From: David Easton
Sent: 02 June 2017 16:06
To: Nicola Spencer; Karen Parsons
Subject: FW: FG/52/17/HH - 31 Upper West Drive

From: Wayne Gander [REDACTED]
Sent: 23 May 2017 13:04
To: David Easton
Cc: 'Nathan Lodge'
Subject: RE: FG/52/17/HH - 31 Upper West Drive

Following our conversation in relation to the above application I can confirm that the rendering of the existing dwelling and proposed extensions would require planning permission. Therefore, if this is something your client wishes to have changed then I would need written confirmation of your agreement to an extension of time until **6th July 2017**. This would allow for the application to be re-advertised.

FRONT

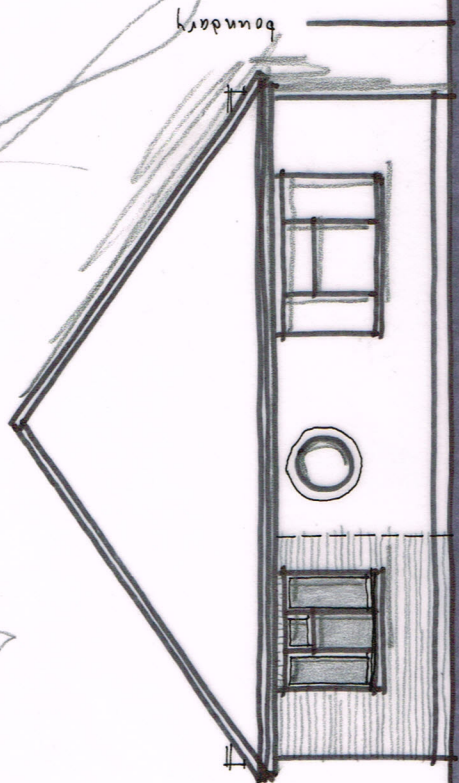
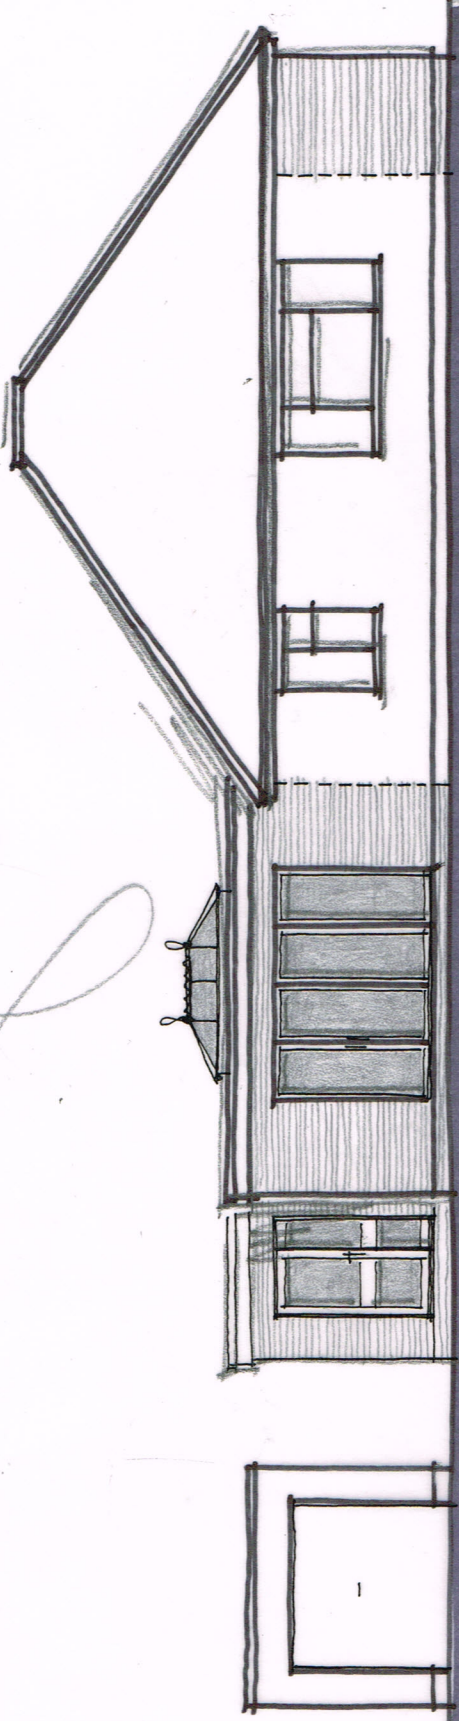
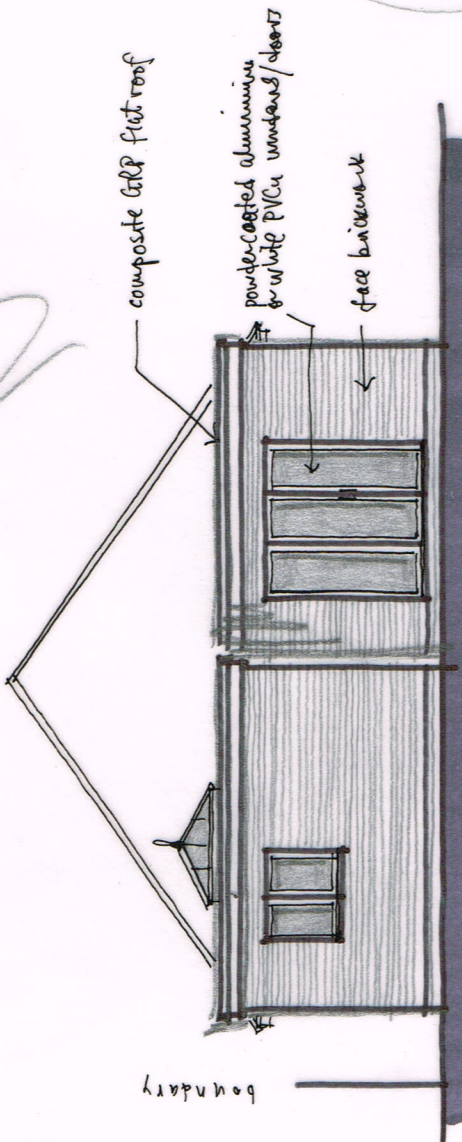
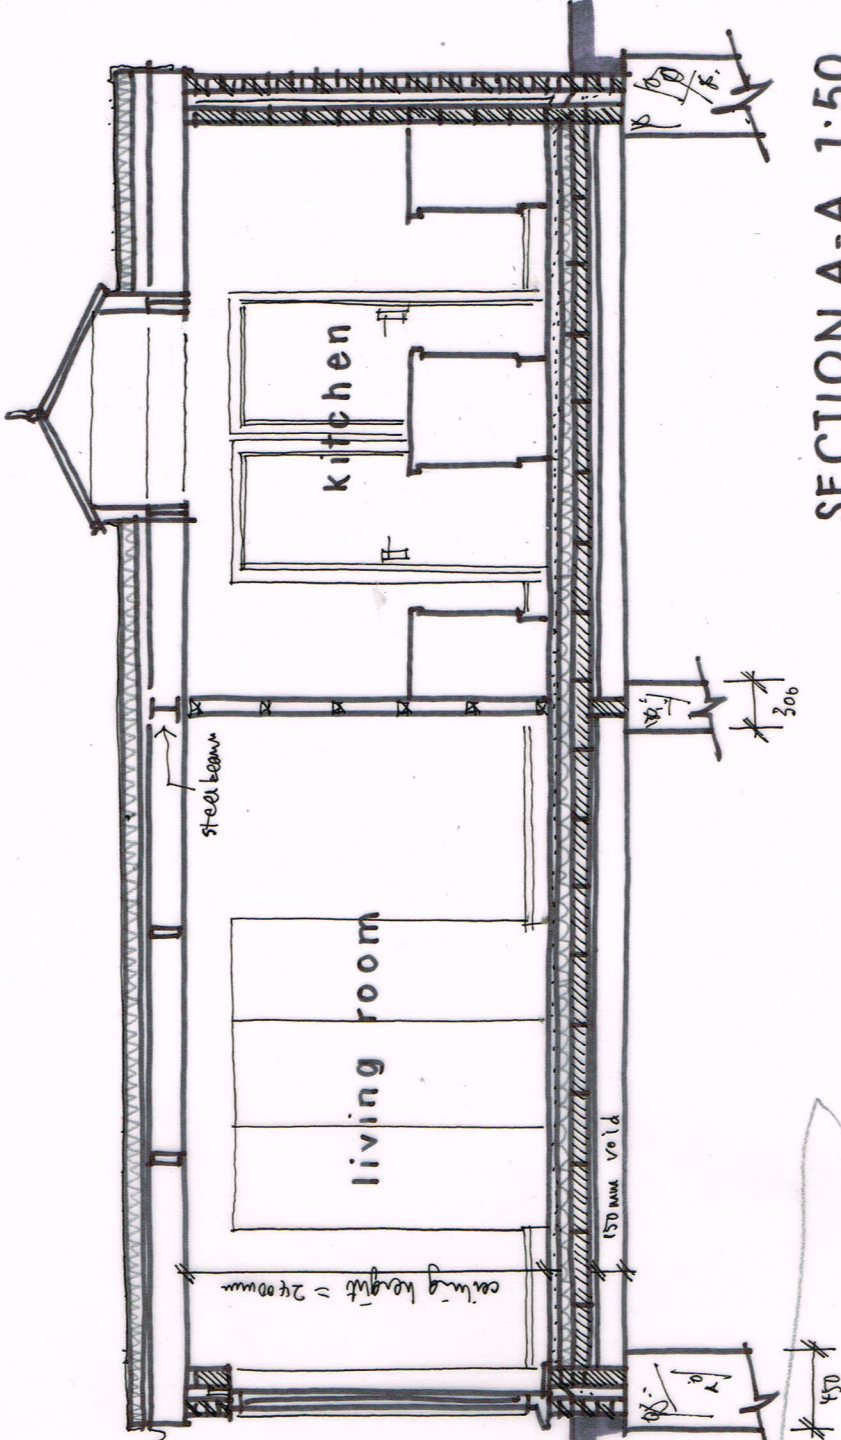
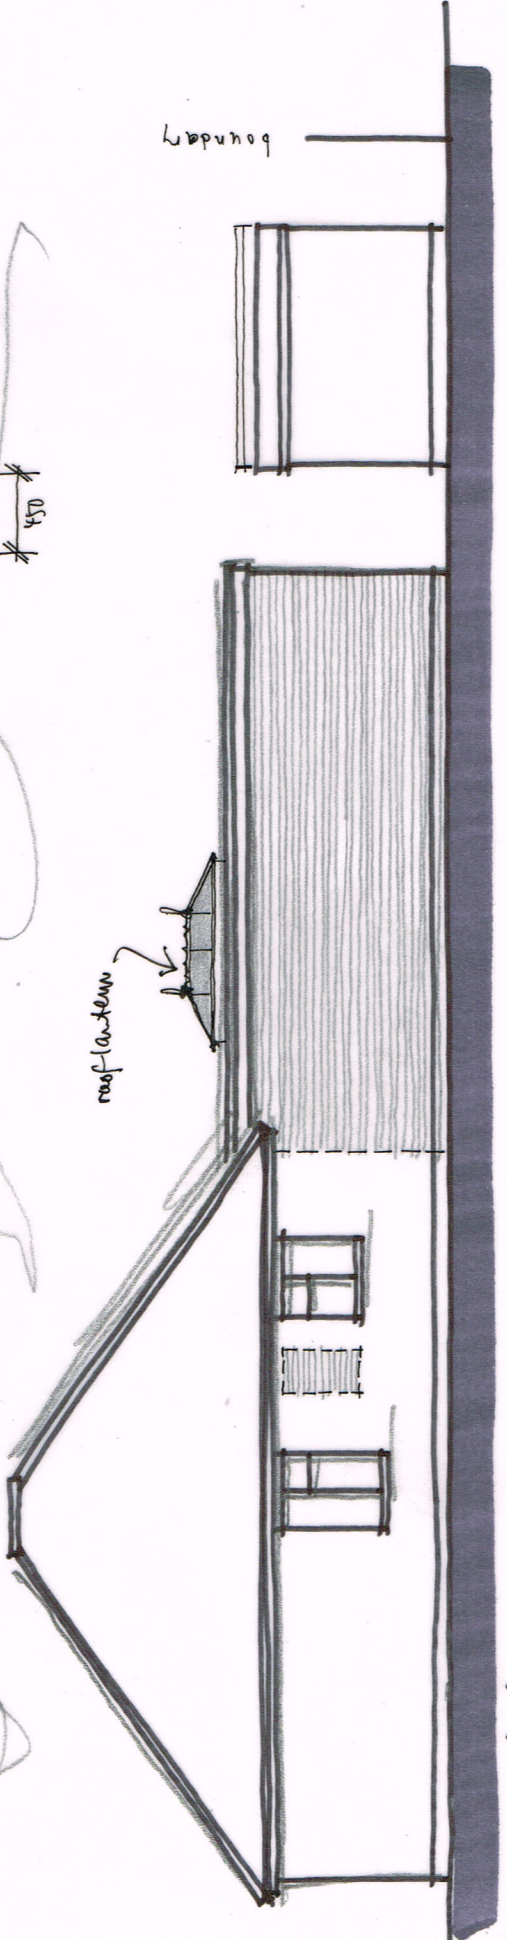
I would also be grateful if you could provide amended documents to reflect the change in the proposal. Please do not hesitate to contact me should you wish to discuss this further.

I wish to confirm the external finish of the proposed extension will be render and the existing brickwork to the bungalow will also be finished in render. The windows will be finished in grey not white, revised drawings attached. I hereby agree to the EOT as noted.
